**From:**  
**Sent:** 25 October 2025 13:18  
**To:** DC Admin  
**Cc:**  
**Subject:** Planning Application 2025/62/91880/E

**Ref: Planning Application 2025/62/91880/E**  
**Erection of single storey rear extension and associated alterations (within a Conservation Area).**  
**14 Manor Road, Farnley Tyas, Huddersfield, HD4 6UL**

I note that an amended Proposed Site/Block layout plan (Drawing No. 25/1196/05a) has been submitted in connection with this application.

scale 1:500 date 05/2025 sheet size A4 dwg. no. 25/1196/05b

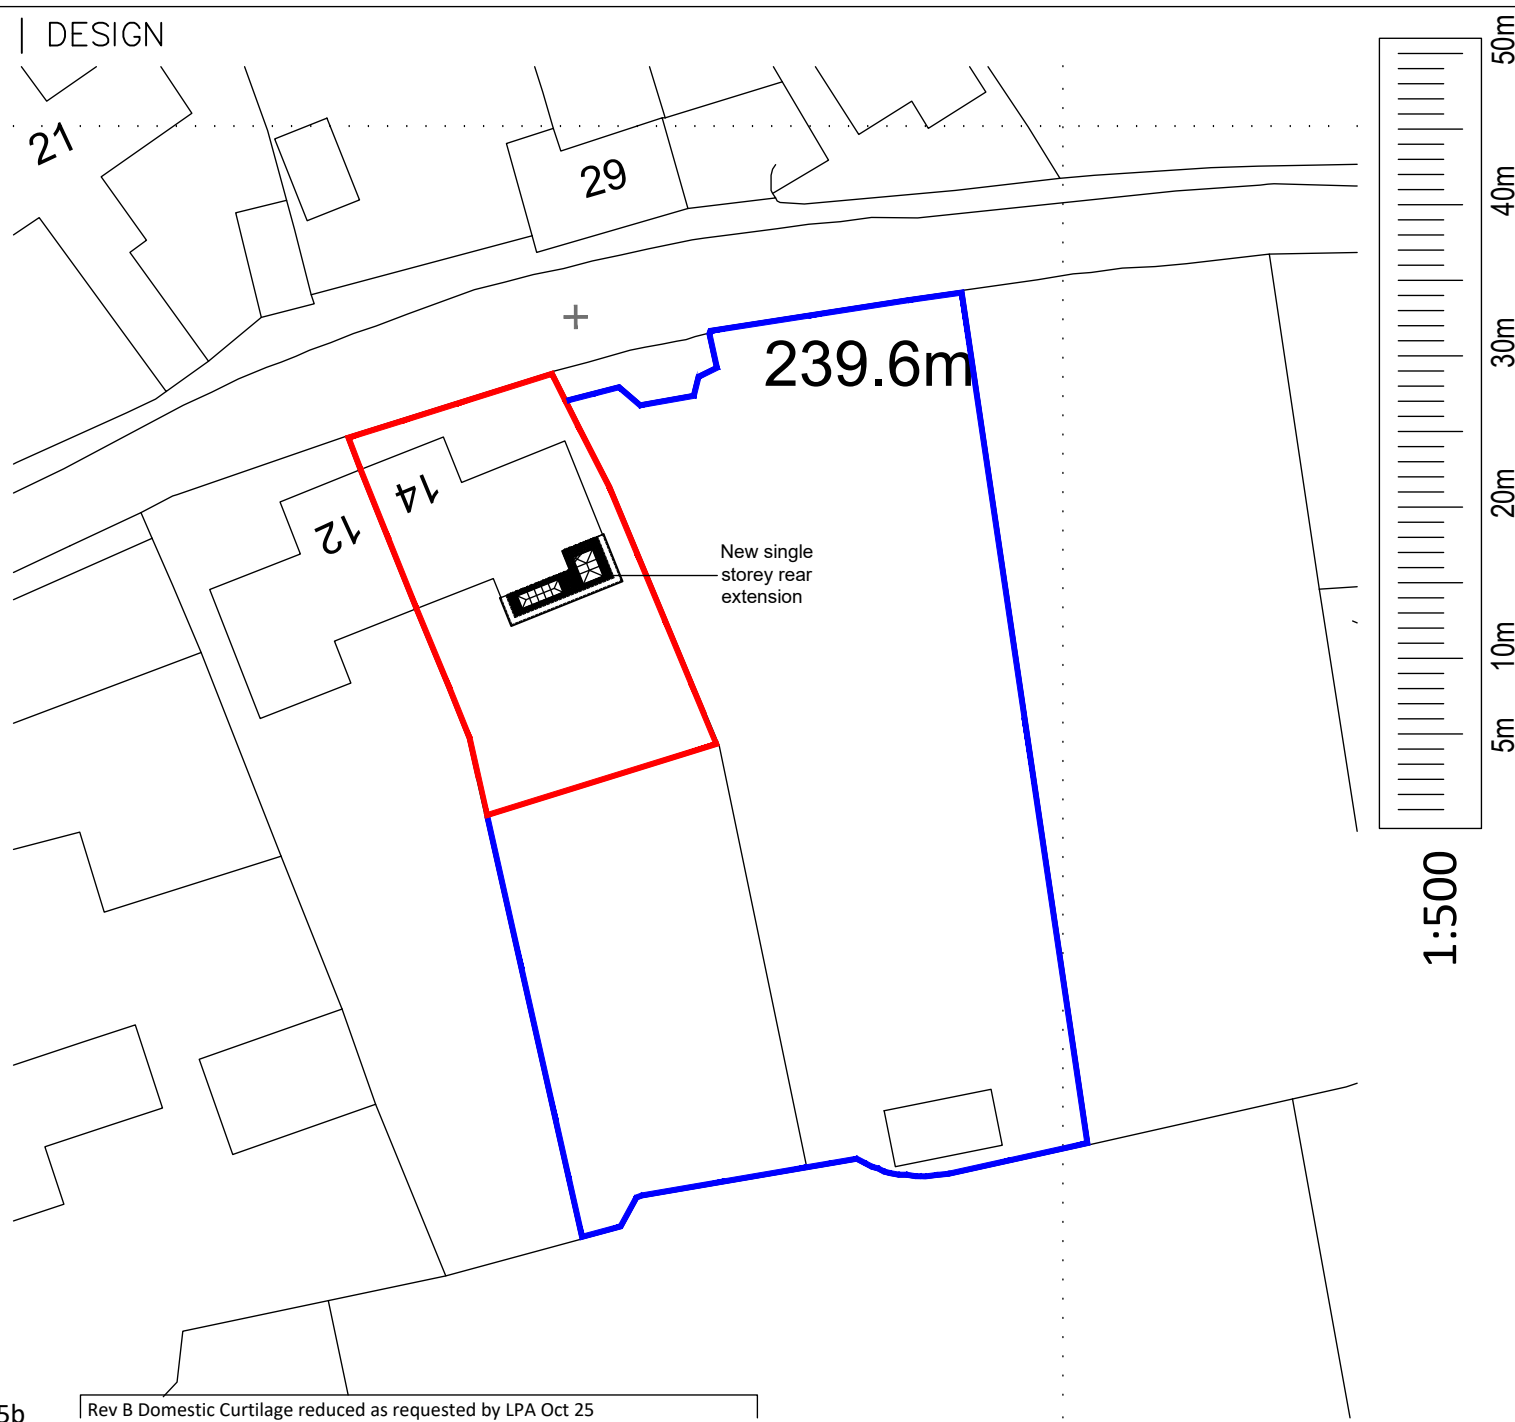
With reference to my previous comments and objection to this application, I note that the red line of the application domestic site boundary is still indicated as encroaching into the paddock area which is incorrect.

As I mentioned previously, this area of land has never been granted a change of use from paddock to domestic dwelling.
